Stage 1 Road Safety Audit

**Phase 1 of Residential Development,
Rosshill, Galway**

On behalf of **Alber Developments Ltd**

July 2021

01 Site Connections & Road Hierarchy Diagram
Scale: 1:750

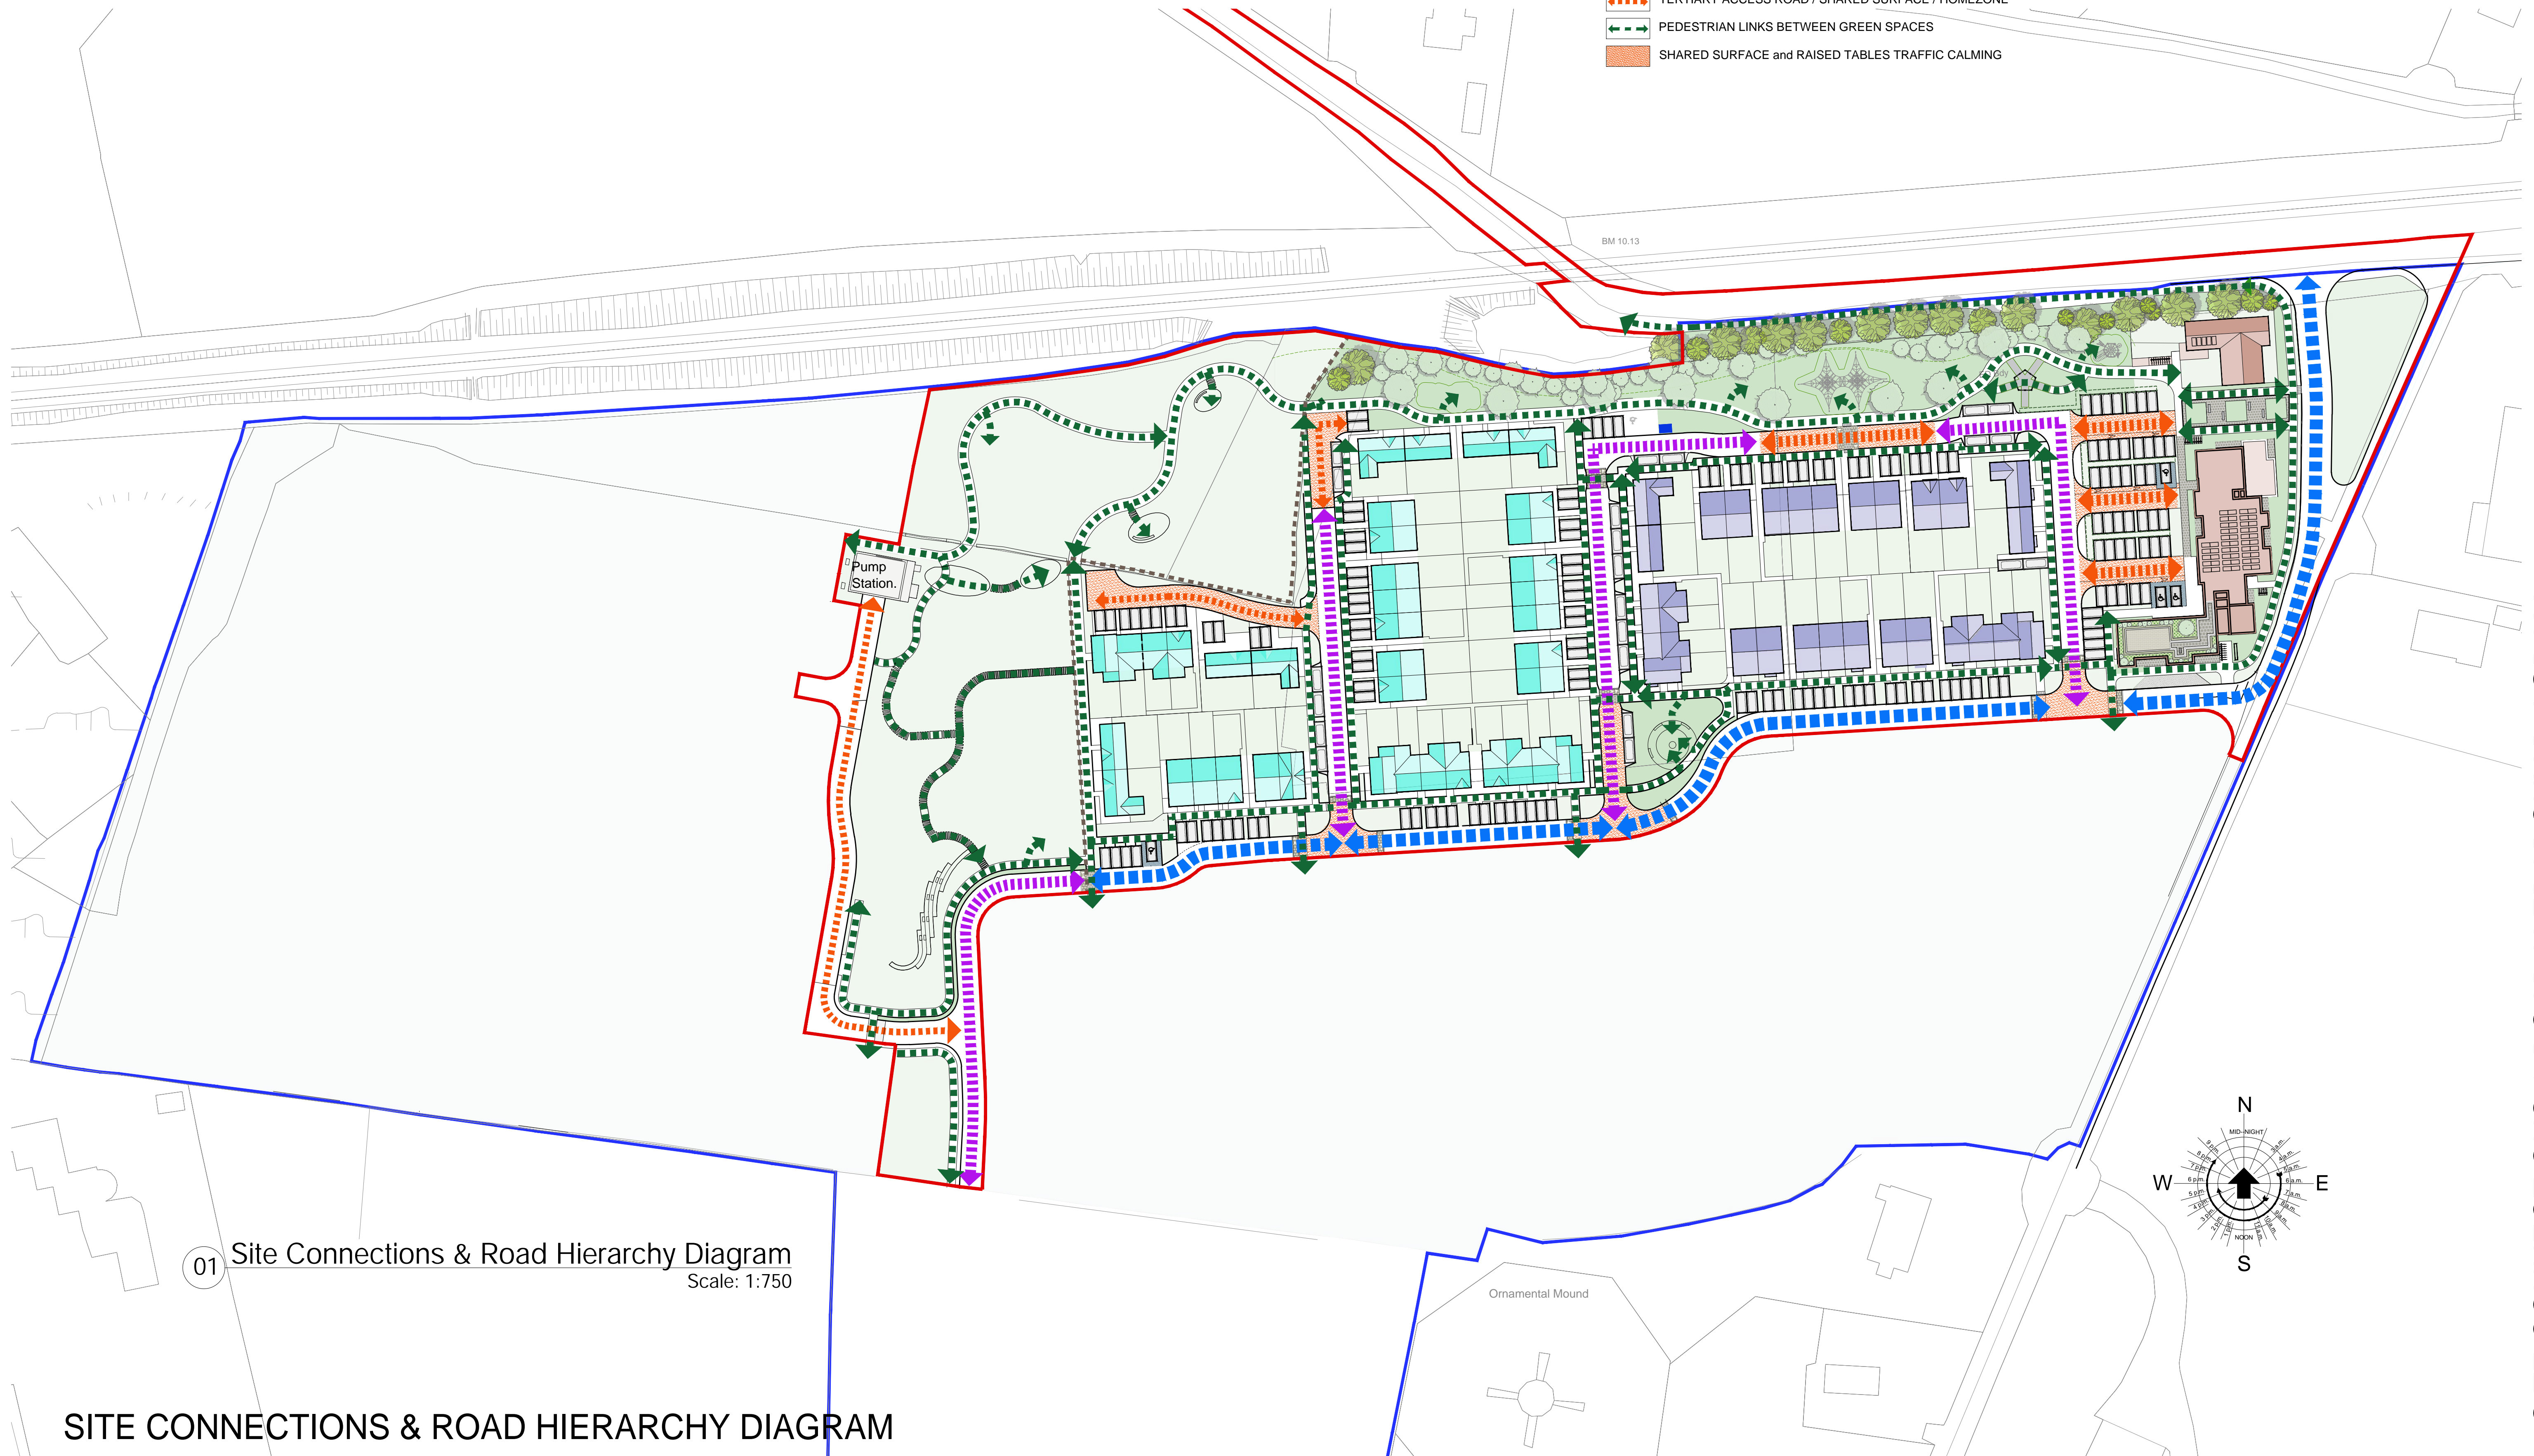
Problem: Visibility at some of the sharp bends on the internal roads may be restricted due to the parking to the inside of the bend. This parking could limit driver visibility around the bend.

Hazard: Motorists may collide with pedestrians who are crossing the road or opposing traffic whose swept path crosses theirs.

Recommendation: Ensure suitable forward visibility is achieved.
DMURS chapter 4.4.4 can be used as a reference document for the design of the internal roads.

2.2.5 Development Roads: Turning Heads

Problem: The internal turning heads seem short. Refuse collection vehicles may reverse back to make use of the road junctions for turning.

Hazard: Impact with crossing pedestrians, cyclists or other road users may result.

Recommendation: Ensure the turning heads are of sufficient size for turning of large vehicles.

2.2.6 Development Roads: Pedestrian Crossing

Problem: Tactile paving is not shown at all footpath crossings of internal carriageways.

Hazard: Sight impaired may errantly enter the carriageway and become confused / not find the receiving footpath / continue to walk in the carriageway. Impact with crossing pedestrians and vehicles may result.

Recommendation: Ensure adequate crossing facilities are provided to facilitate safe crossing points for vulnerable road users.

2.3.9 Chicane to Southwest of Phase 1

Problem: Perpendicular parking off a short sharp chicane to the southwest of Phase 1 has restricted visibility due to the further parking to the west.

Hazard: Motorists pulling out of the parking, particularly those reversing, may pull into the path of oncoming traffic and be struck.

Recommendation: Realign the road or remove some parking so that adequate visibility is achieved.

Title: Drainage Layout (Sheet 1 of 2)

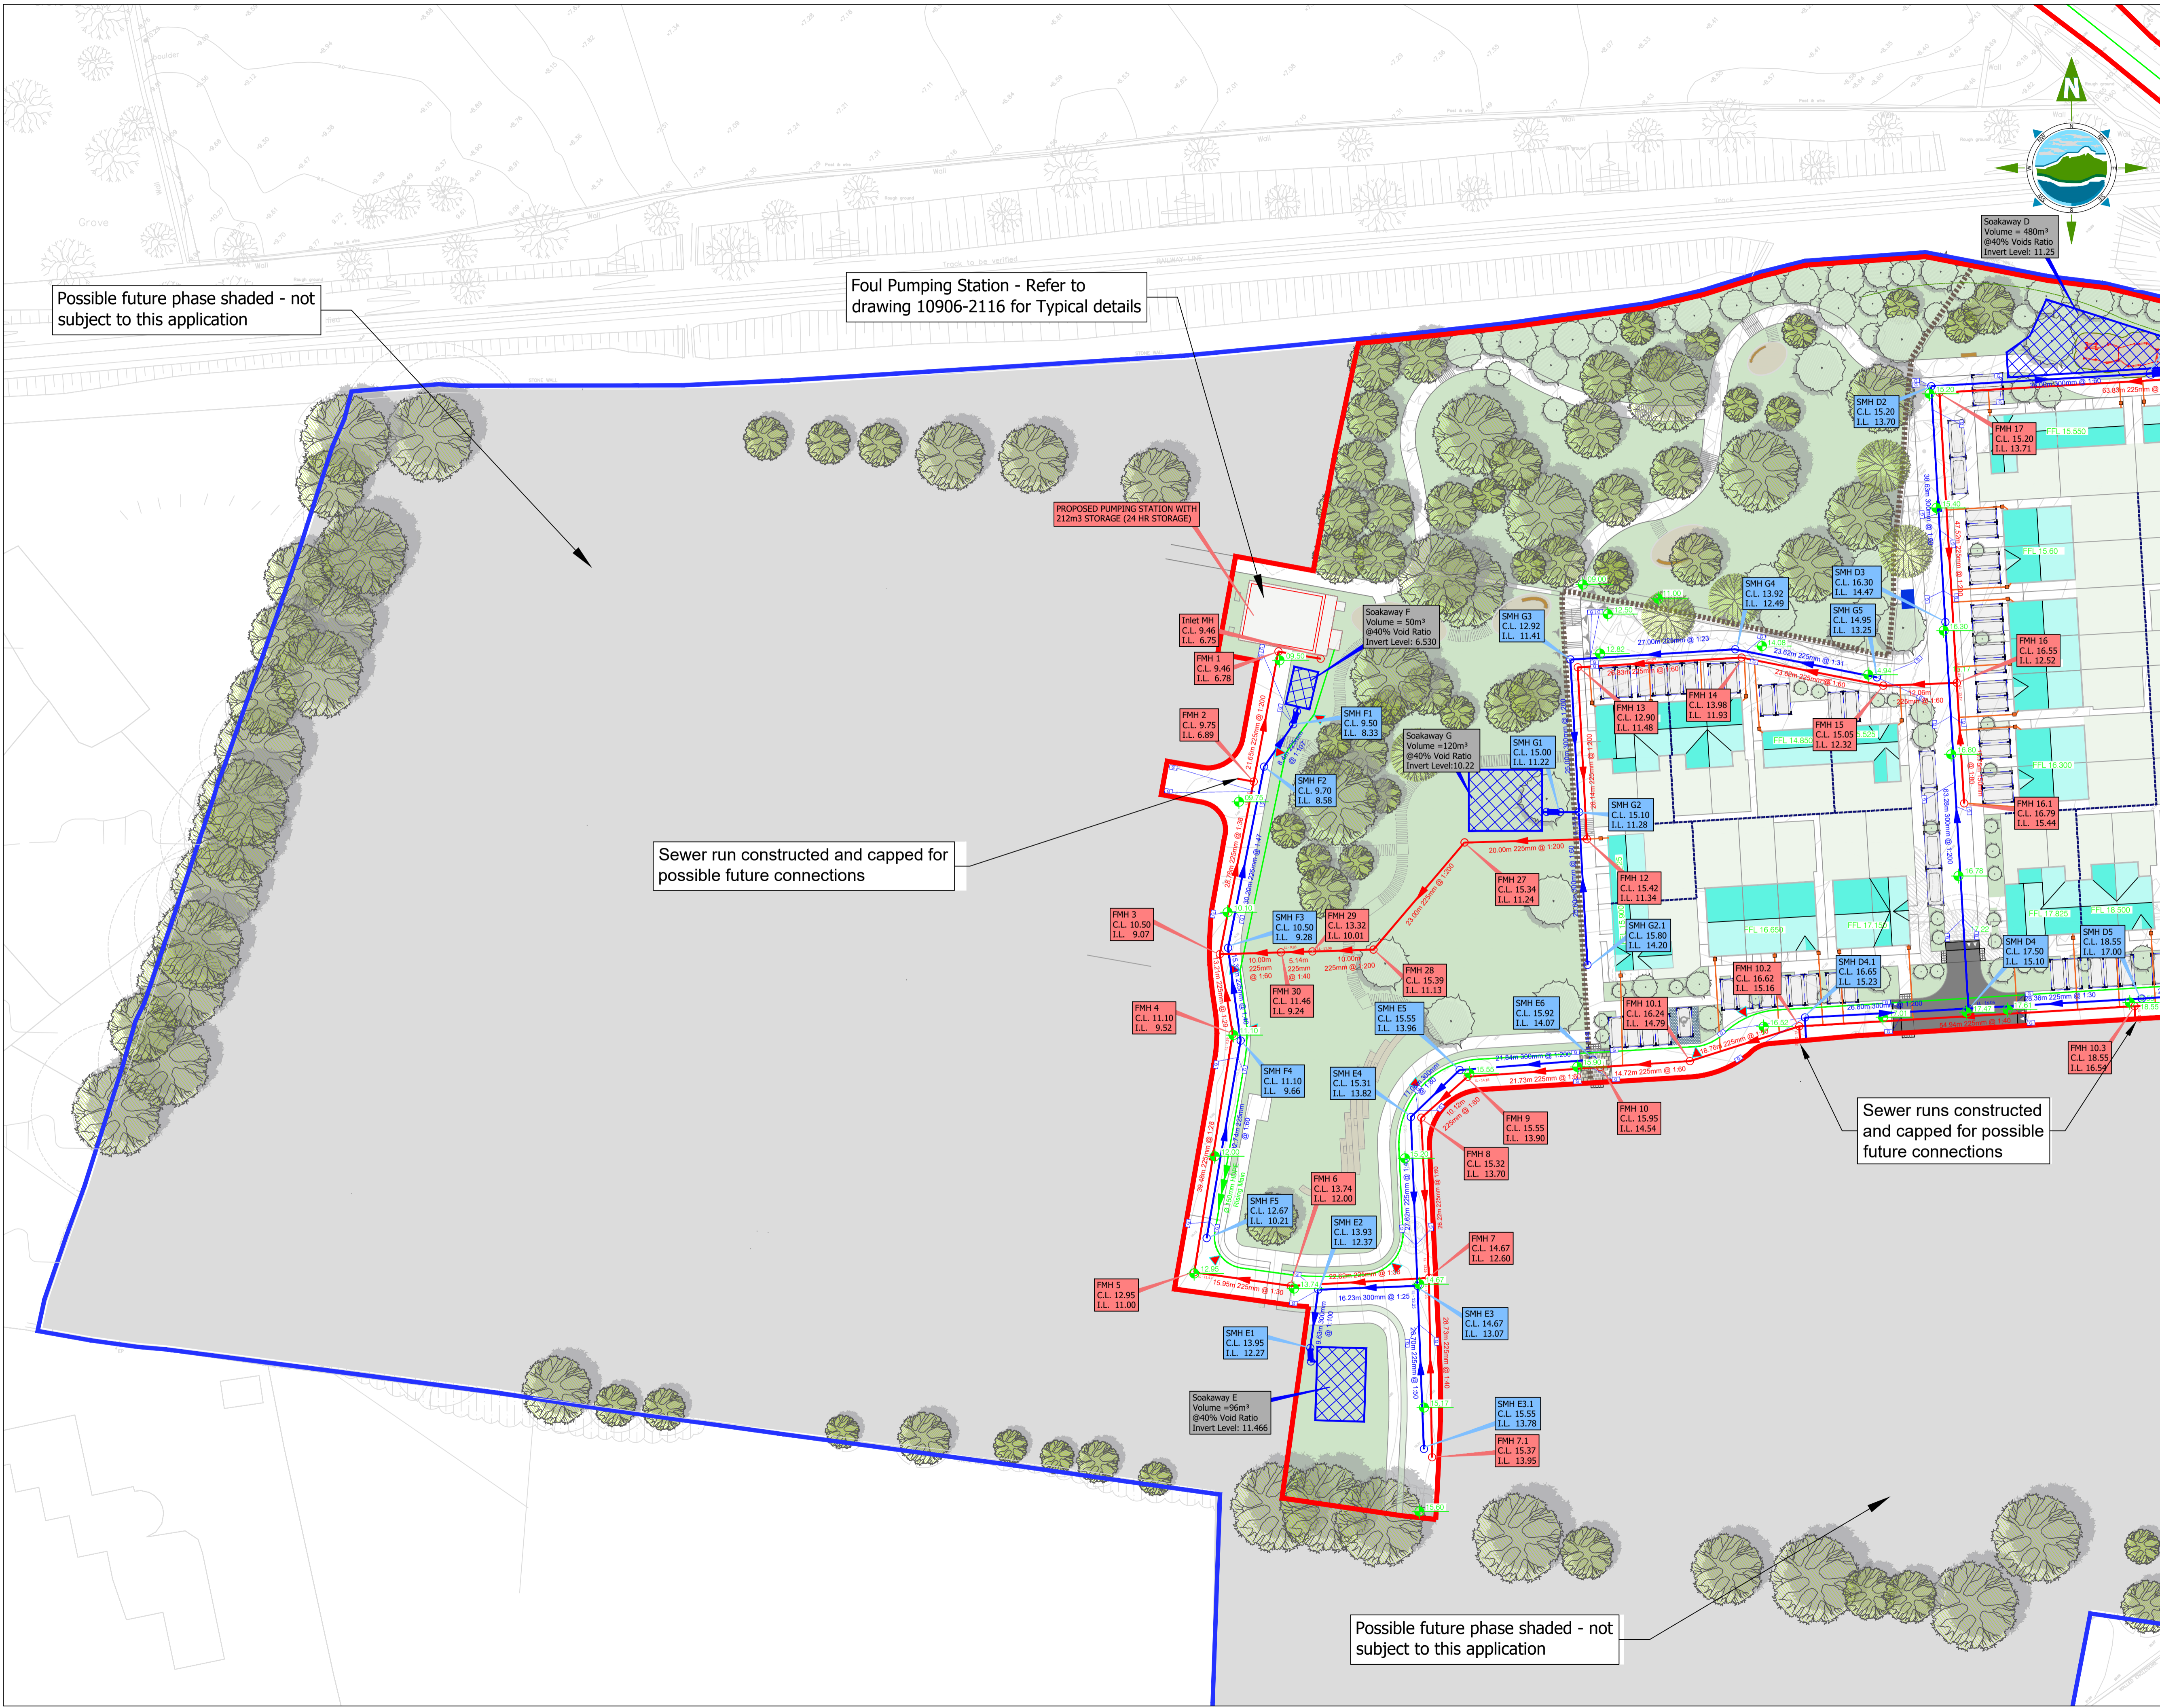
2.3.6 Rosshill Road: Drainage

Problem: The existing Rosshill Road drainage is not working adequately. The development will generate increased traffic movements on this road.

Hazard: During times of extreme rainfall standing water may encroach into the carriageway. Risk of vehicular loss of control will be heightened by the increased use of this road.

Recommendation: Ensure adequate surface water drainage is provided.
